**TALASAEA**  
CONSULTANTS, INC.

12 April 2019

REFERENCE:       **Hou Critical Areas Determination**  
FILE NOS.:        CAO17-010 and SEP19-003, Ecology SEPA #201900882  
SUBJECT:          Response to City of Mercer Island Comment Letter

Revisions	By	Date
Date	7-21-2017	
Scale	1"=20'	
Designed	AQ	
Drawn	MW	
Checked	OA	
Approved	ES	
Project	#1124B	
Sheet #	W11

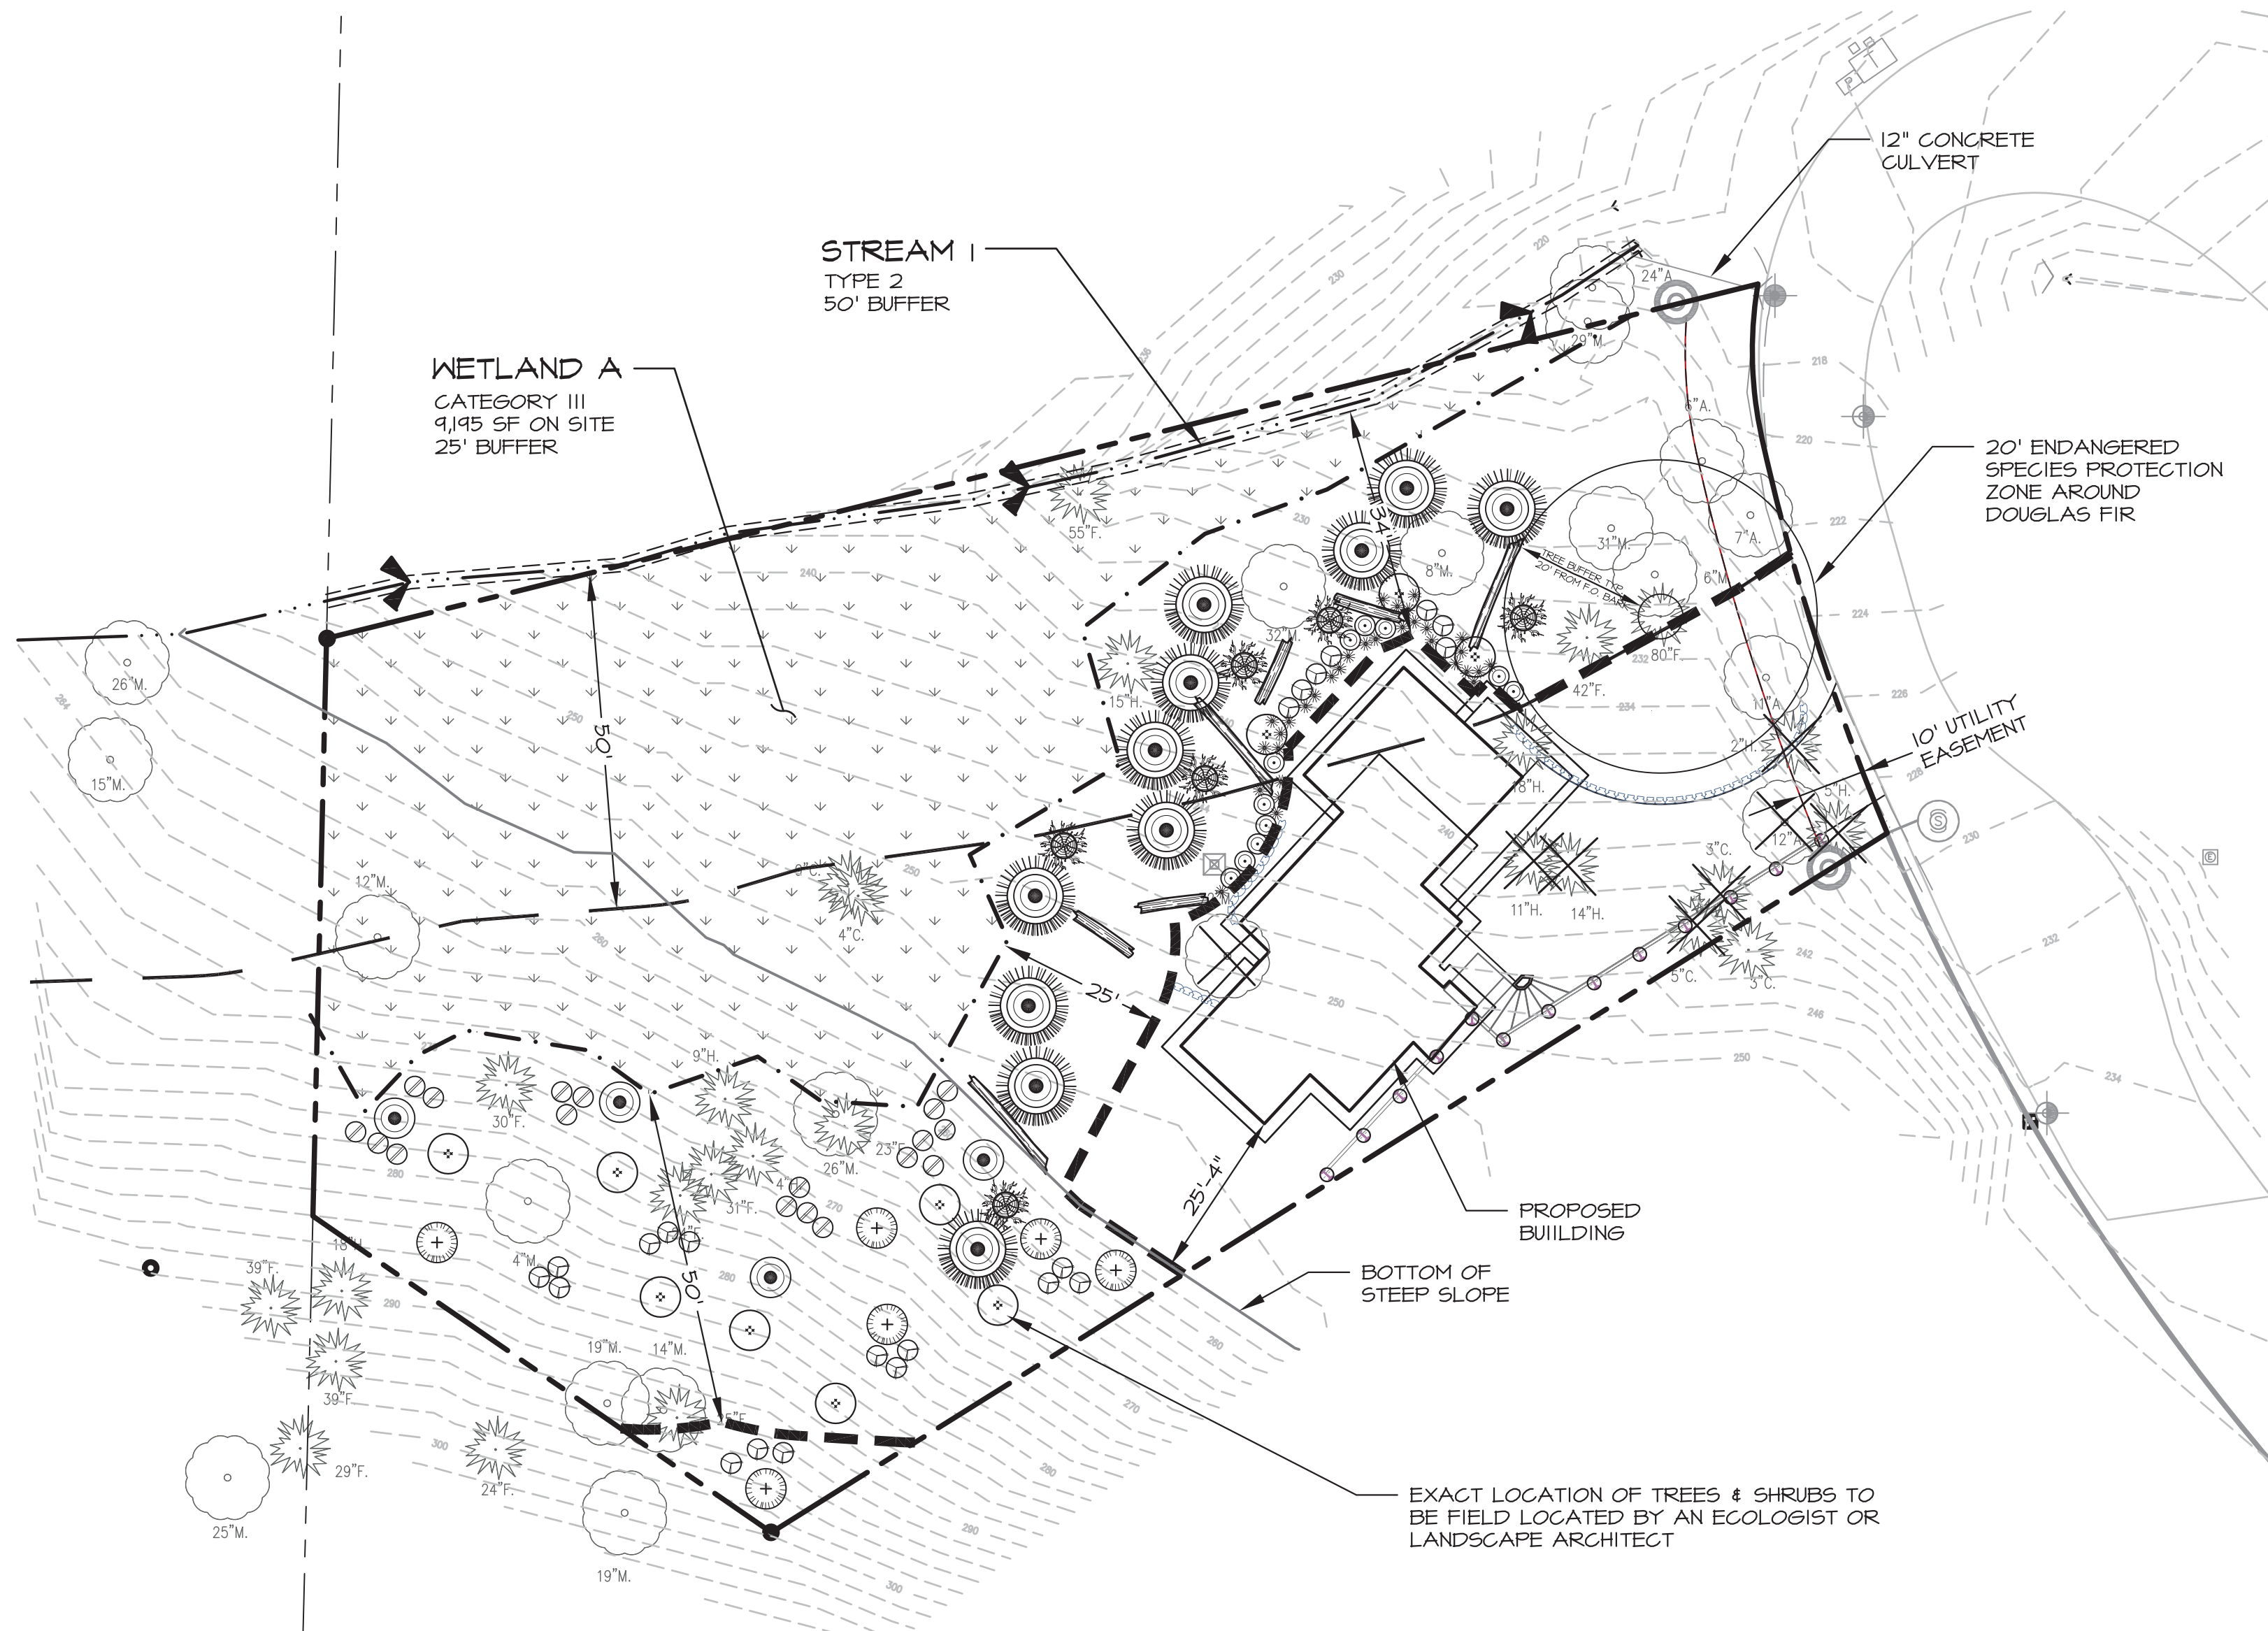
**Ecology would regulate the wetland as a water of the state subject to the applicable requirements of state law (see RCW 90.48 and WAC 173.201A) and Section 401 of the Clean Water Act (33 USC §1341) and 40 CFR Section 121.2. We are concerned about the buffer encroachment and do not support building the house so close to the wetland. This is not consistent with Ecology guidance on buffer widths in Wetland Mitigation in Washington State – Part 1: Agency Policies and Guidance (Publication #06-06-011a).**

*That said, the wetland buffer is being reduced to 25 feet for a short segment, with some buffer give-back provided in conjunction with vegetative enhancement of the remaining buffers to compensate for the reduced buffers. This is necessary to provide a buildable area on this lot that would otherwise be undevelopable. This parcel and associated critical areas are located within the boundaries of the City of Mercer Island, a relatively densely developed jurisdiction considering it is mostly single-family residences. The presence of critical areas cannot preclude development on this lot as it is zoned for residential use and is surrounded by single-family residences. Every step has been taken to avoid direct impacts to the wetland, to minimize indirect impacts to the wetland as much as possible given the development constraints on this Site, and to mitigate for the anticipated indirect impacts from the reduced buffer. No further modifications to this wetland buffer are anticipated, nor are any changes proposed as a response to this question.*
